**Our ref:** 26\_36628\_P

**Your ref:** H06-0819-26**Site Location:** Land south of Blazegate and West of Gedney Drain Gedney Spalding**Summary of Proposal:** Change of use of land to a residential caravan site comprising 4 Gypsy/Traveller pitches, each accommodating a static caravan/mobile home and a touring caravan, together with hardstanding, erection of 4 amenity buildings and improvement of existing access - retrospective

The Board's Officers have reviewed the documents submitted in support of the above planning application. Officers have noted works which require Land Drainage Consent from the Board as outlined in the table below and detailed overleaf.

SITE LAYOUT PLAN

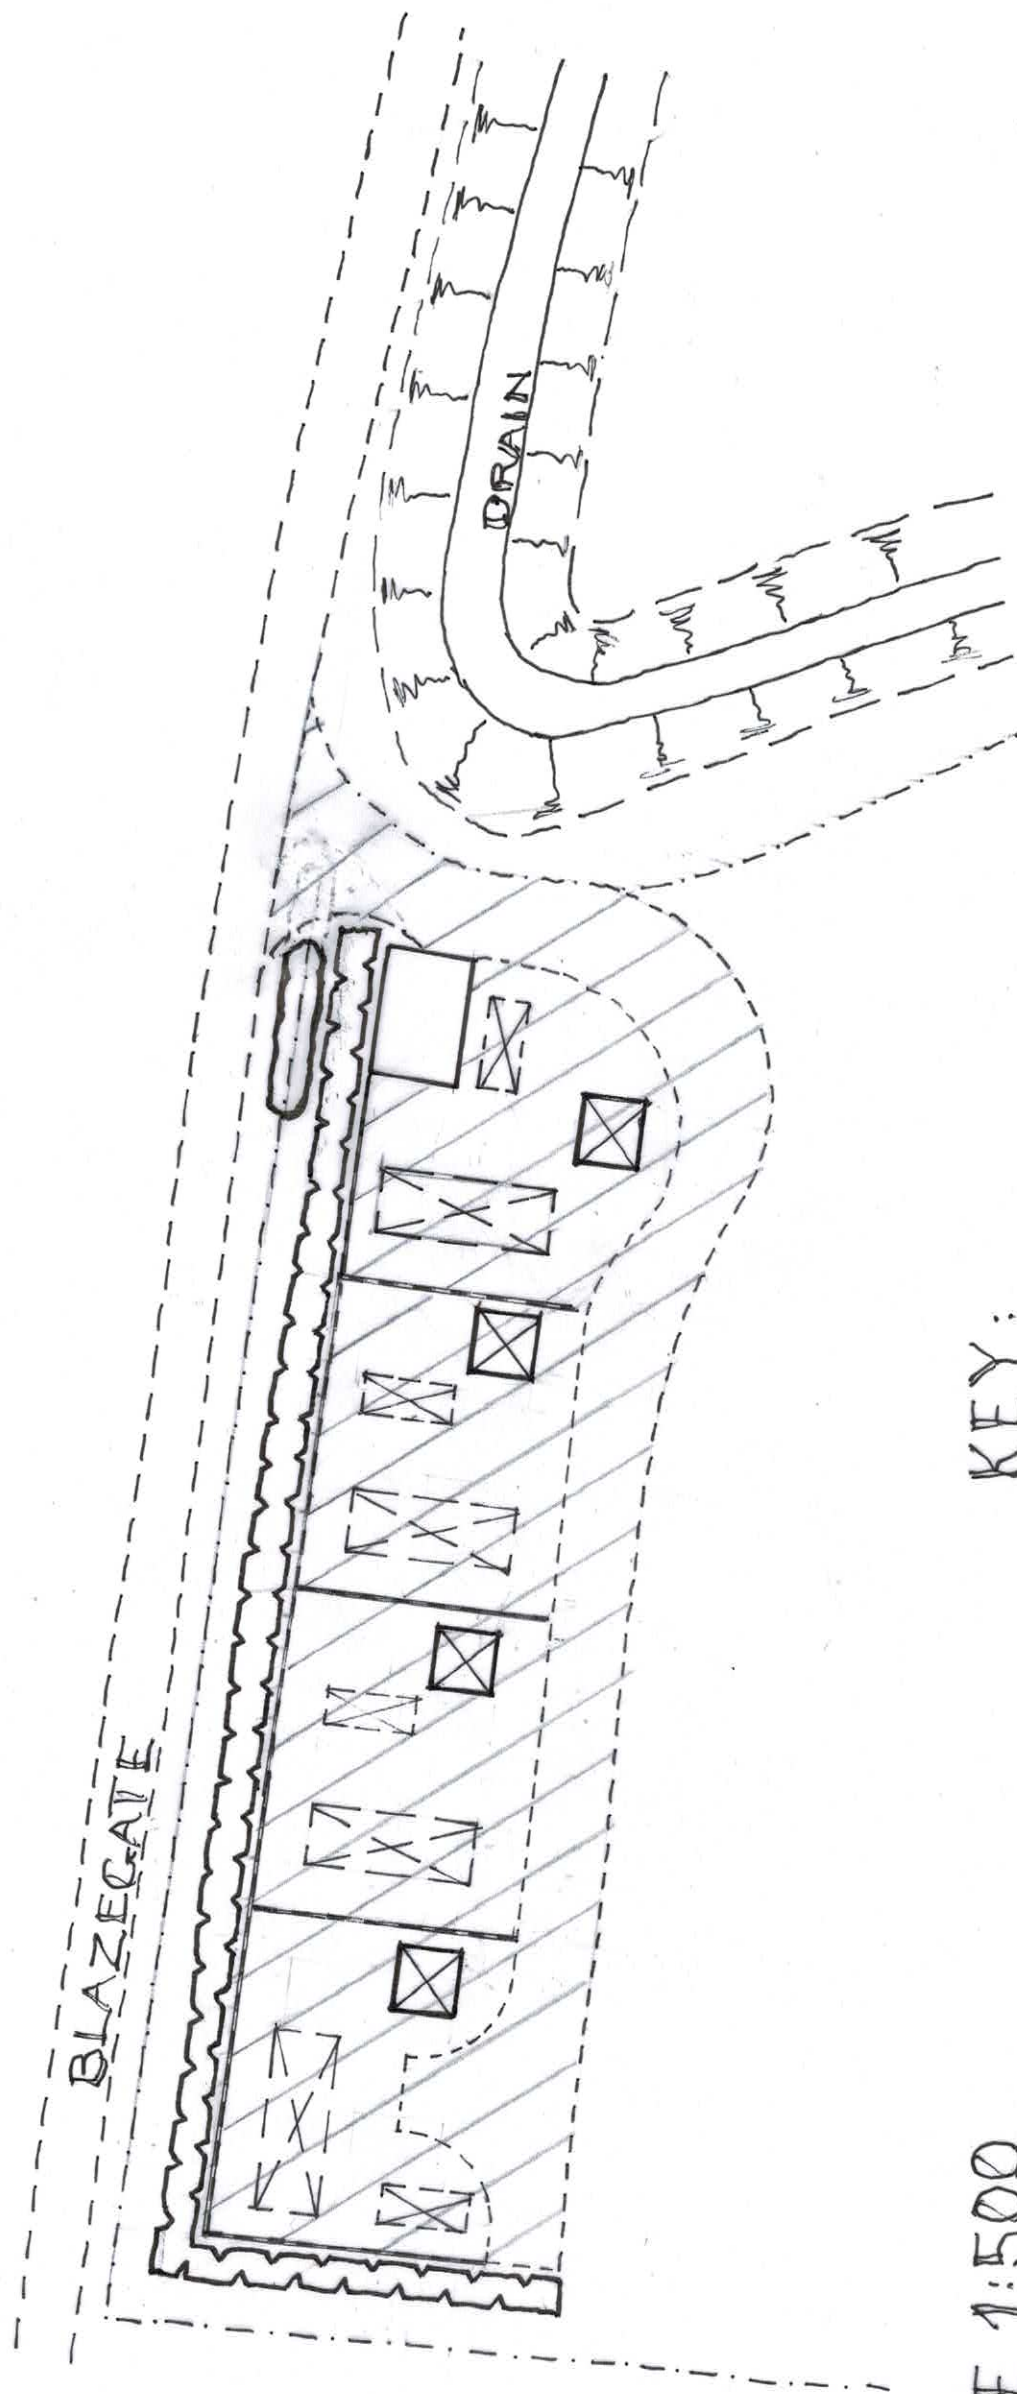
The Board recommends that adequate space (5 metres) is left flat and free from obstruction adjacent to the riparian watercourse in order to enable maintenance by future riparian owners or a designated maintenance company/contractor.

I note within the drawing 'Site Layout Plan PBA 02' (Philip Brown Associates Limited, September 2026) that the applicant intends to erect a new permanent fence line and hardstanding within 9 metres of the aforementioned Board owned arterial watercourse.

This proposal is not acceptable under the Board's [policies](#) due to the impact on the Board's ability to carry out future operations while also likely increasing the liabilities of the Board, therefore the Board **objects** to this proposal.

However, we would welcome a meeting with the applicant to discuss an alternative design which facilitates both the Board's requirements and the applicant's site design. Please could you contact us using the details at the top of the letter so that we can arrange mutually acceptable date and time.
